**Amended Concept Development Application (SSD-9579) for an Over Station Development (OSD) above the new Crows Nest Metro Station including maximum building envelopes, gross floor area, conceptual land uses, car spaces and signage zones.**

**Submission by Wollstonecraft Precinct Committee (Preliminary)**

5.0 SEPP 65 Analysis
5.3 Shadow Analysis
June 3:00PM - 3:30PM

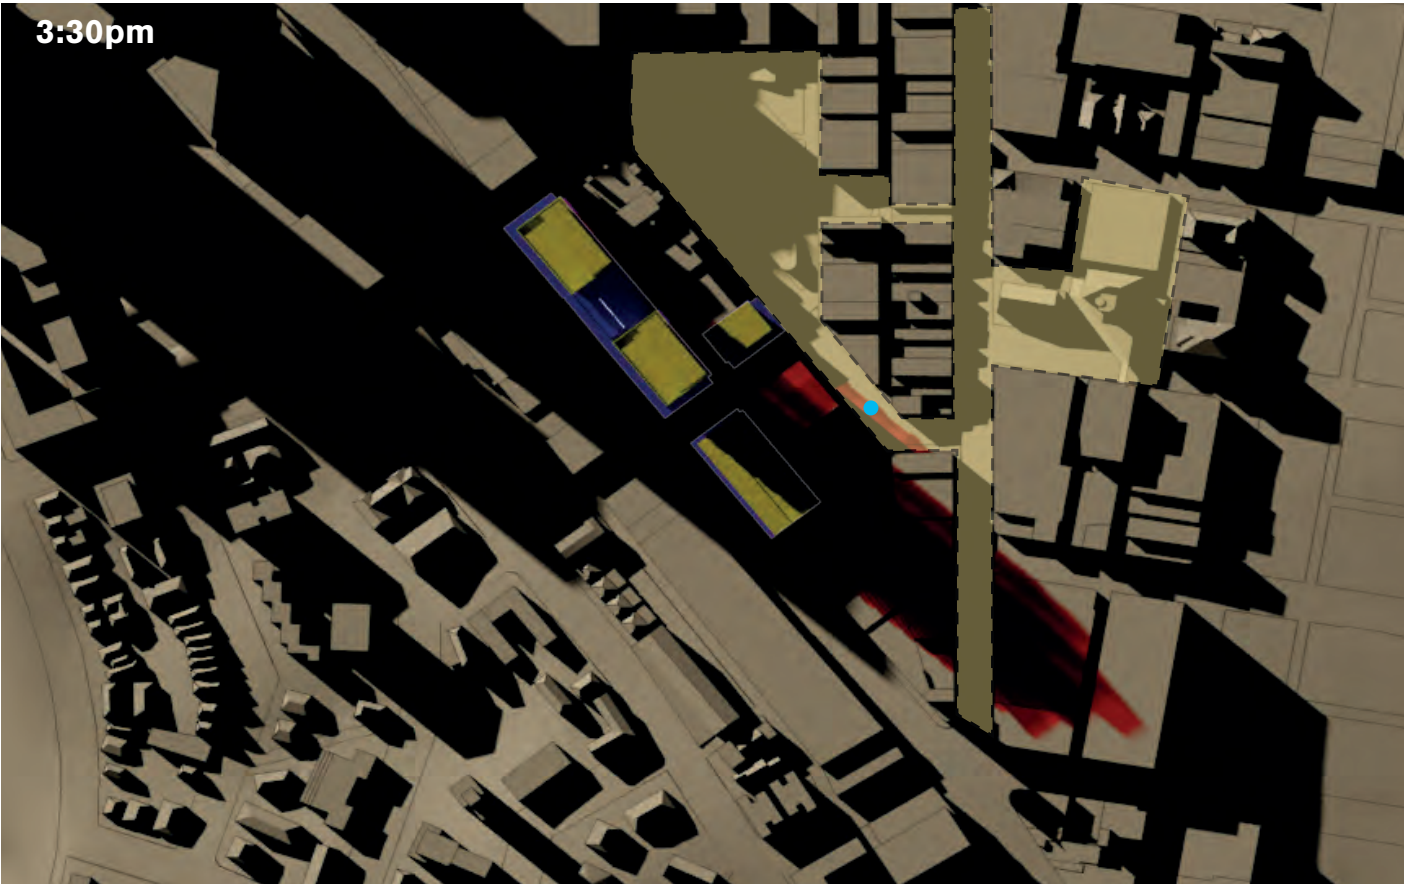
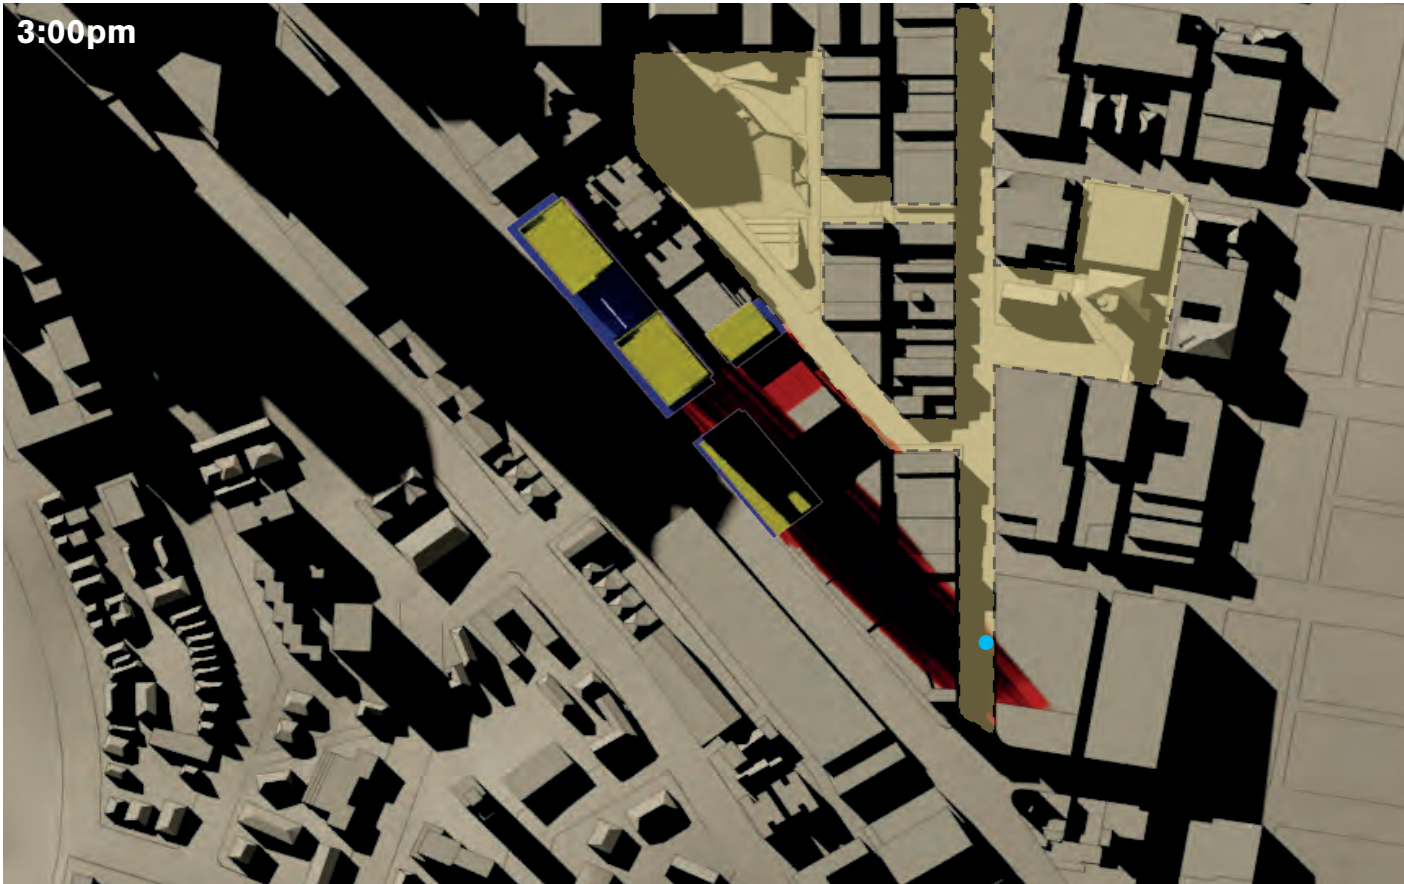
The shadow diagrams for this building, ignore what will now be a future 24 storey mixed use/residential development on the opposite side of the highway. Shadows from that development in the afternoon will eliminate the effect of the stepped face of the OSD building A and as a result worsen the effect of shadowing to Willoughby Road.

### **Issue – overshadowing of Willoughby Road – Comment**
